Town & Country Planning Act 1990 (as amended)
Town & country Planning (Development Management Procedure) (England) Order 2015
Application for Planning Permission for Works or Extension to a Dwelling

Development Annex accommodation in outbuildings & new carport/garage.

Location The Paddocks Eastergate Lane Eastergate

Proposed Site Plan @ 1:500

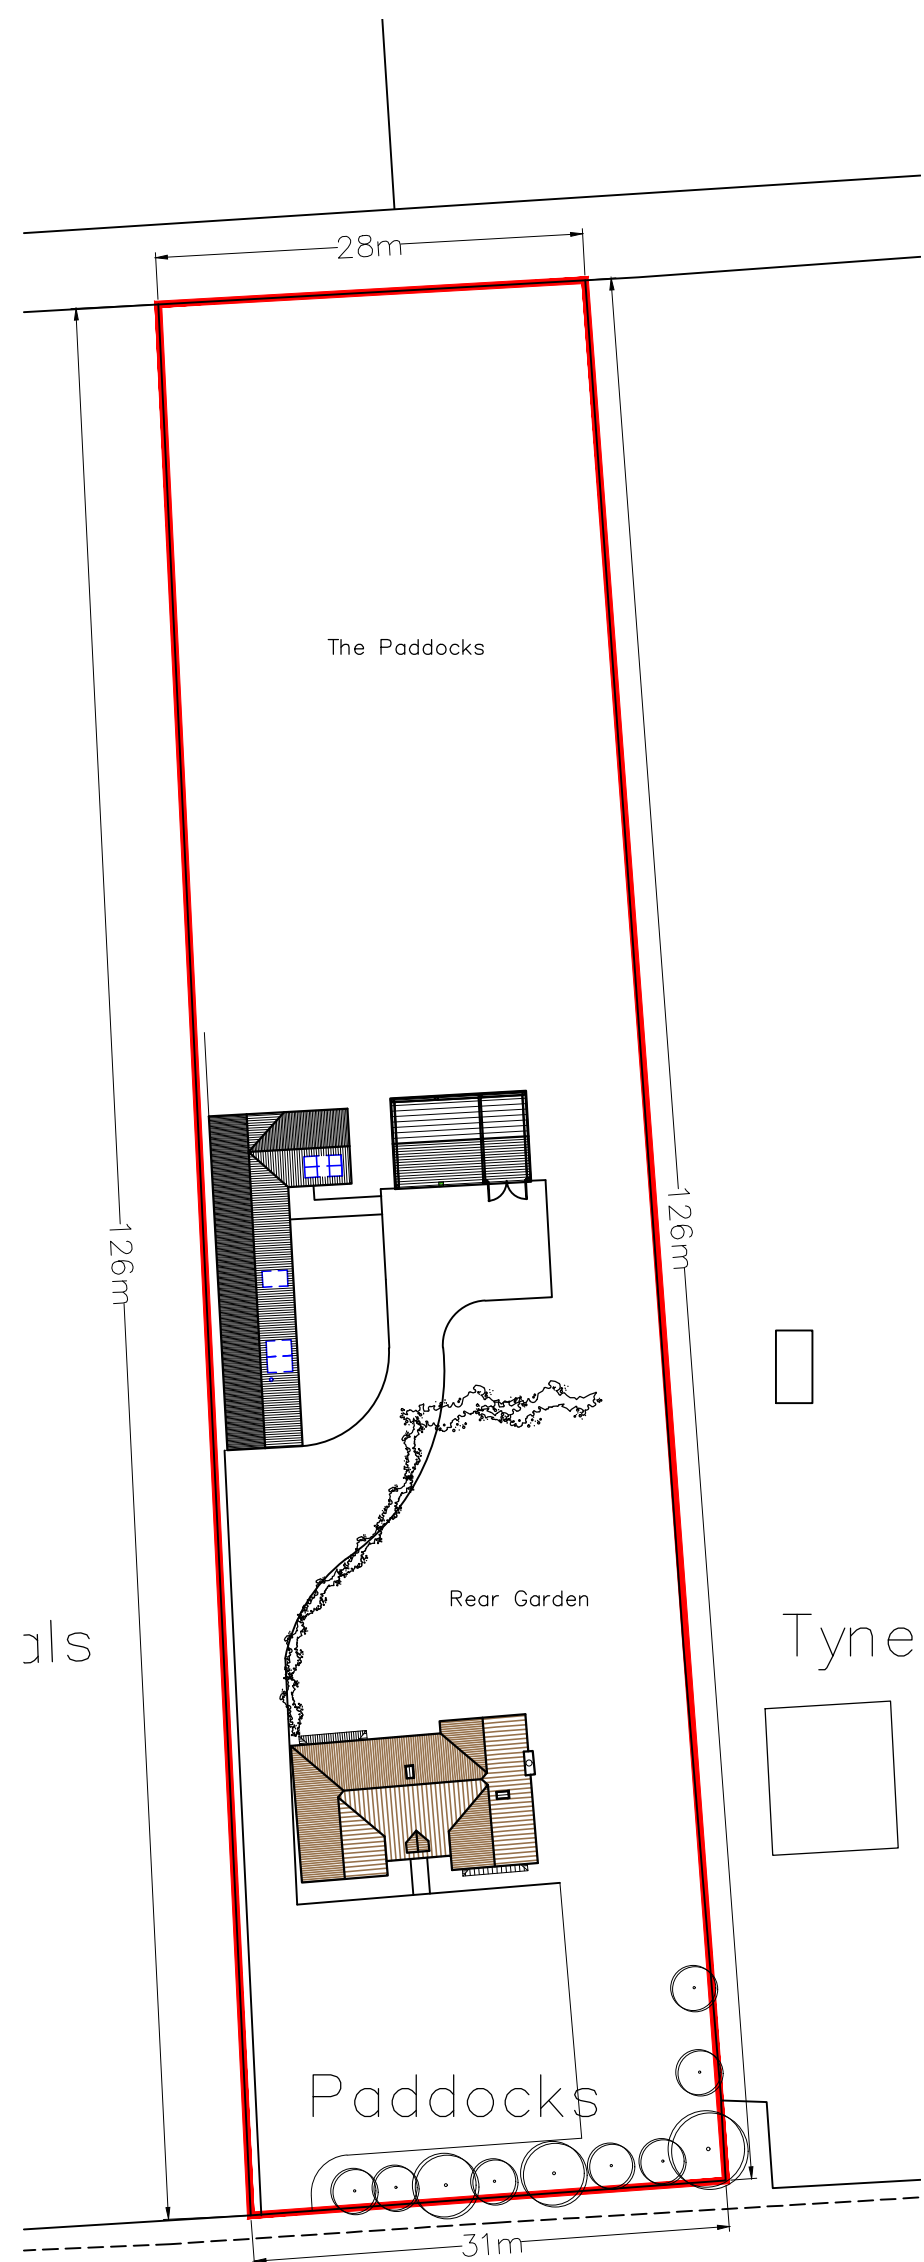
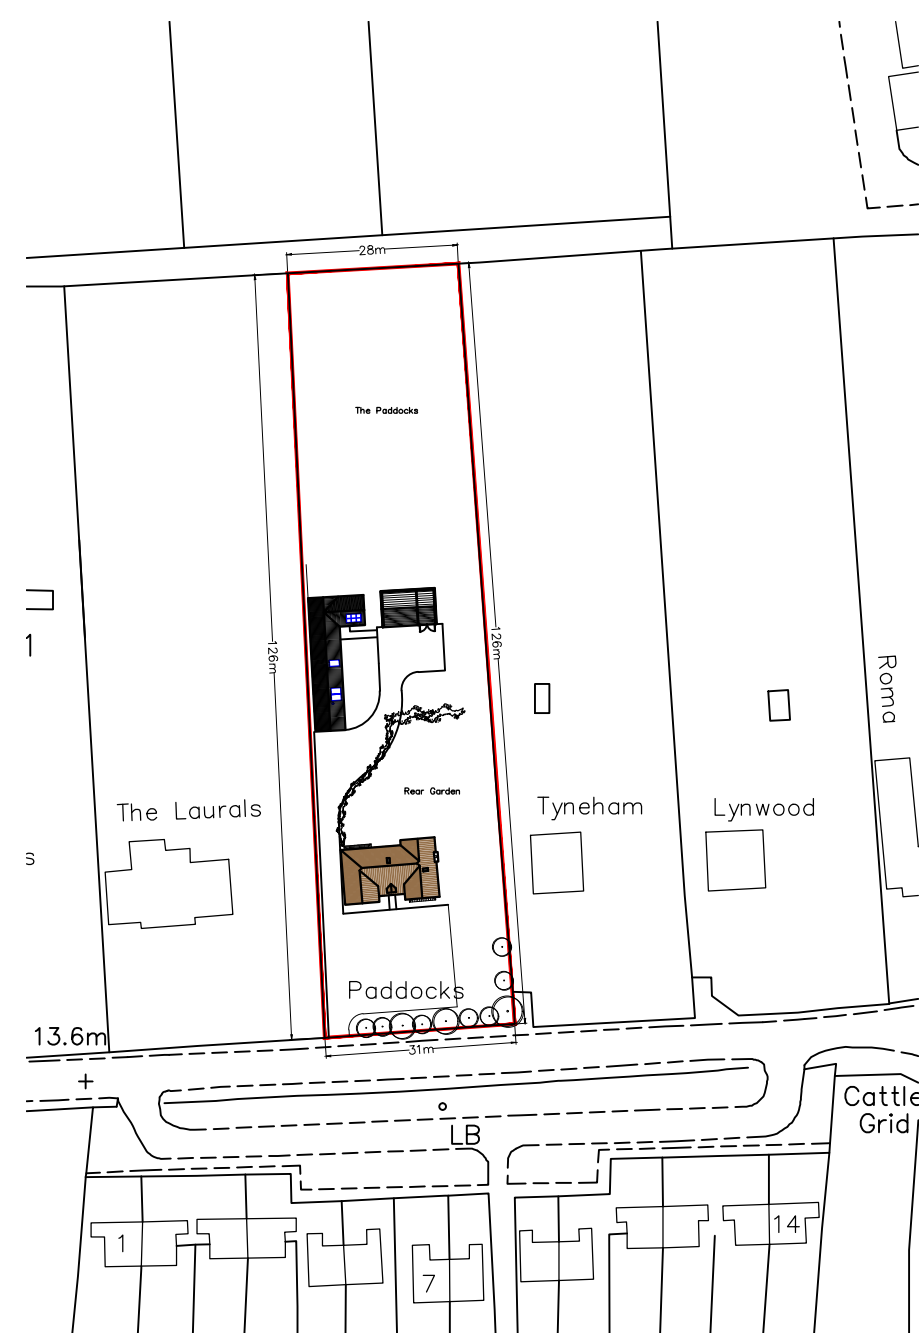
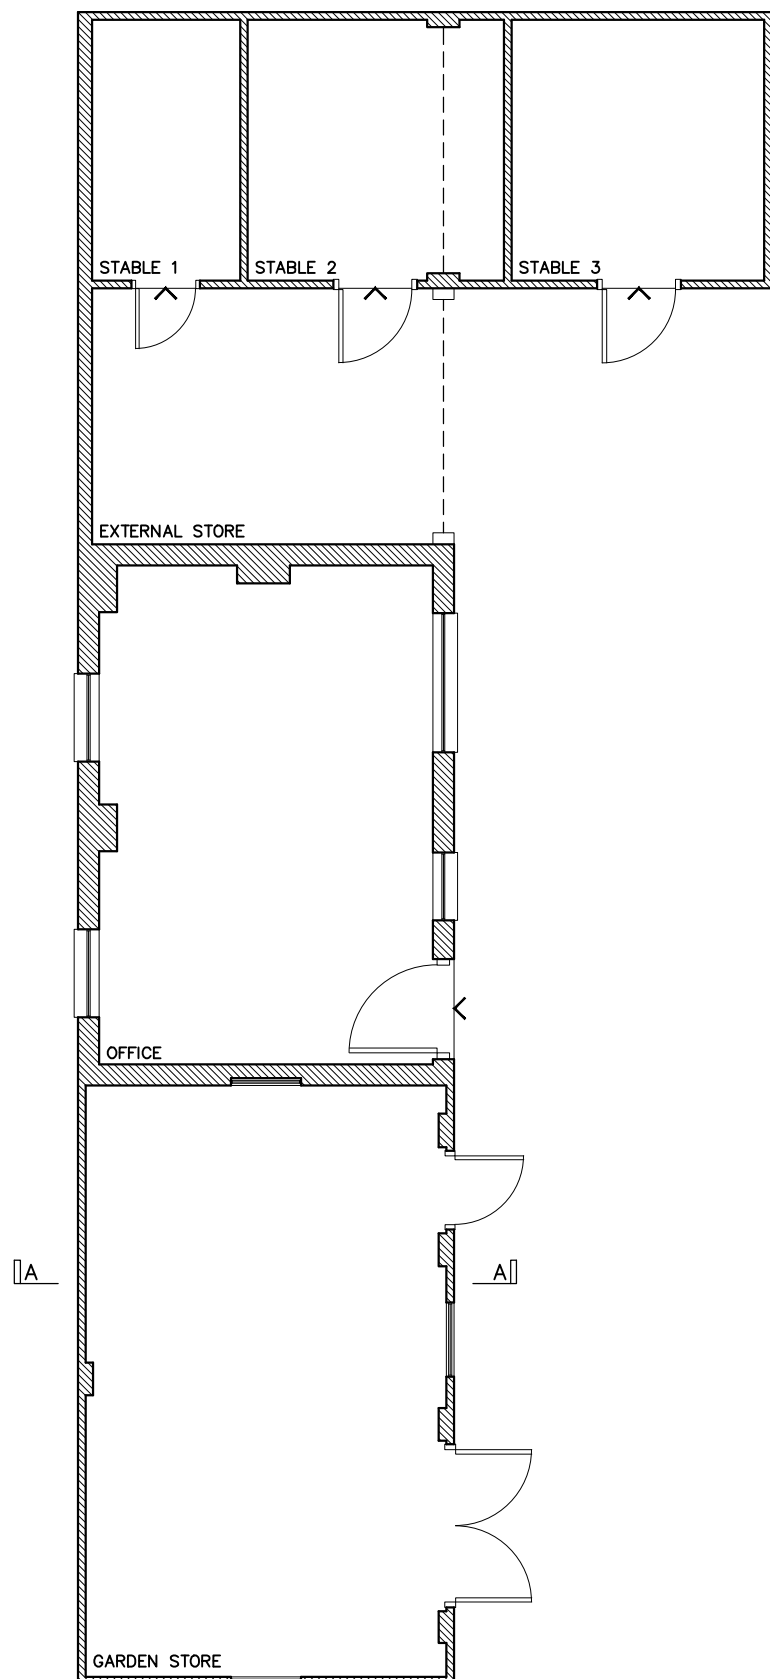
Please label one of the proposed site plans as a Location plan.

Proposed Plan @ 1:100

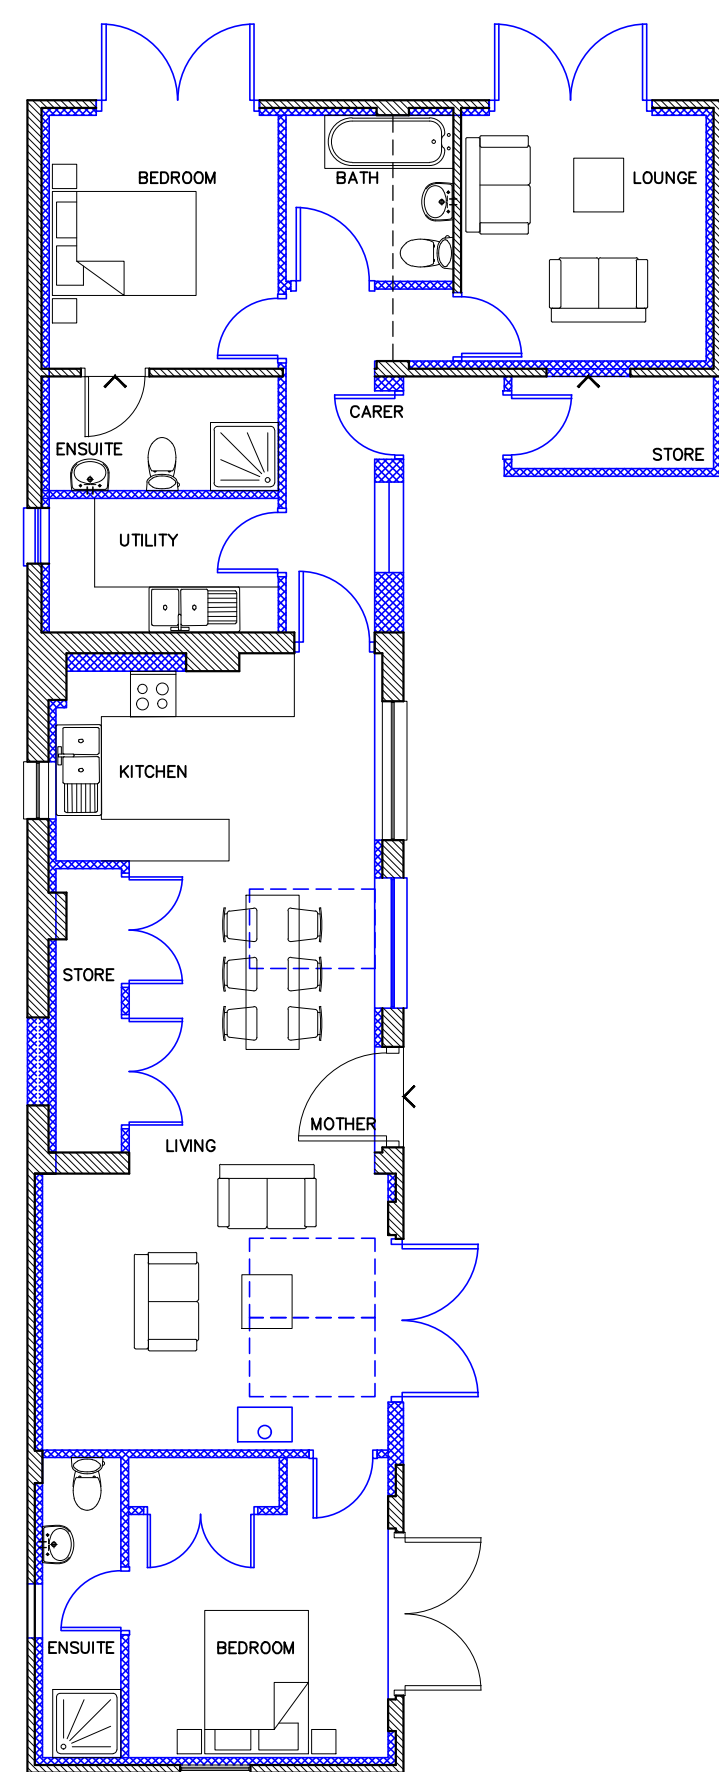
There is a window on the east elevation that does not appear on the east floor plan (lounge). Please amend accordingly.

Proposed East Elevation @ 1:100

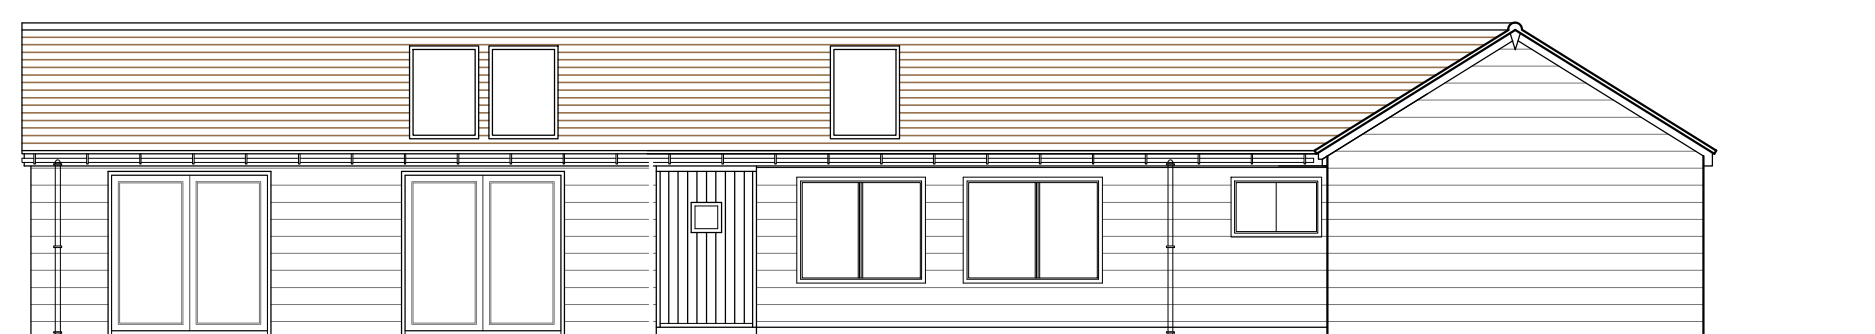
The proposed east elevation window and dining room window do not scale correctly.
